**Growth and Sustainability
Regeneration and Culture
Planning and Building Control**

Ref: 2025/0394
Date: 27th May 2025
Enquiries Jess Duffield
Direct 01226 772589
E-Mail: jessicaduffield@barnsley.gov.uk

RE: Discharge of Conditions 12, 13 and 14 relating to 2024/1060: Alterations to existing car park and provision of new public open space and landscaping with associated works.

SEAM-ONE-Z2-XX-DR-L-00001

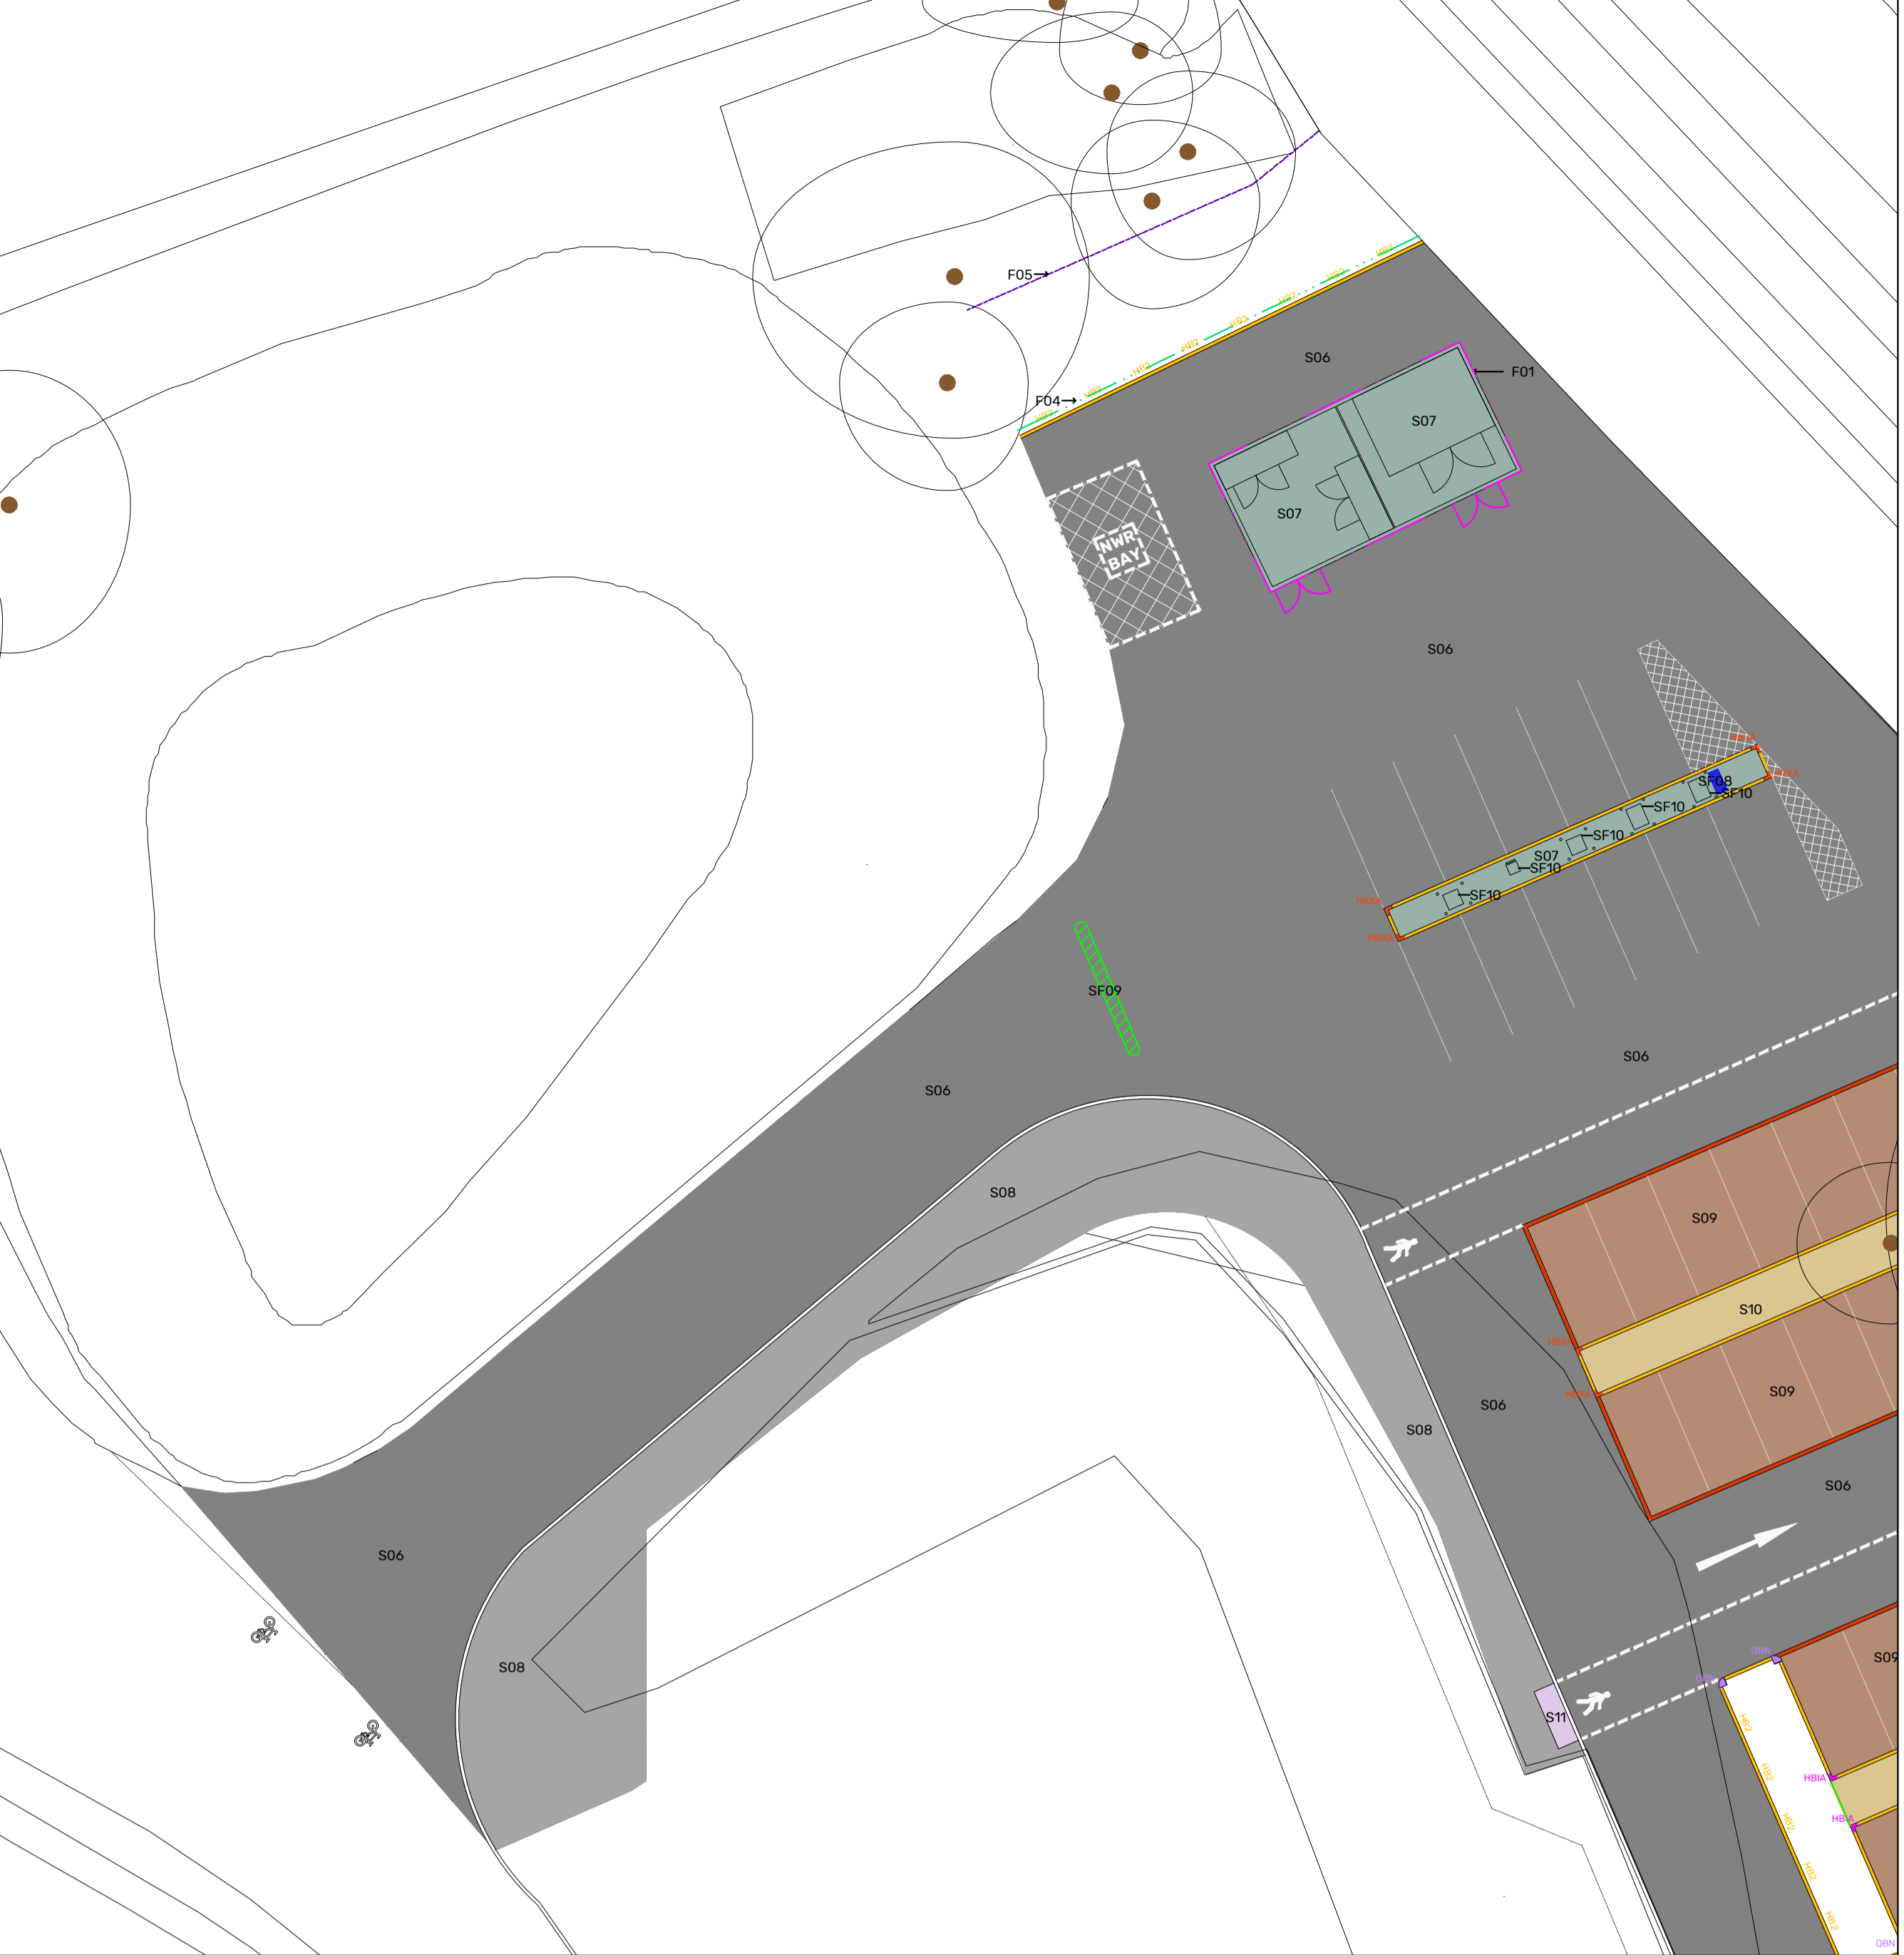
The Urban Design Officer has reviewed the submitted information and is generally supportive of the proposals. However clarification is required regarding the design of the steel enclosure beneath the DMC01 building and the specification of the Granite paving blocks (S05 and S01). Once this information is provided the condition can be discharged in full.
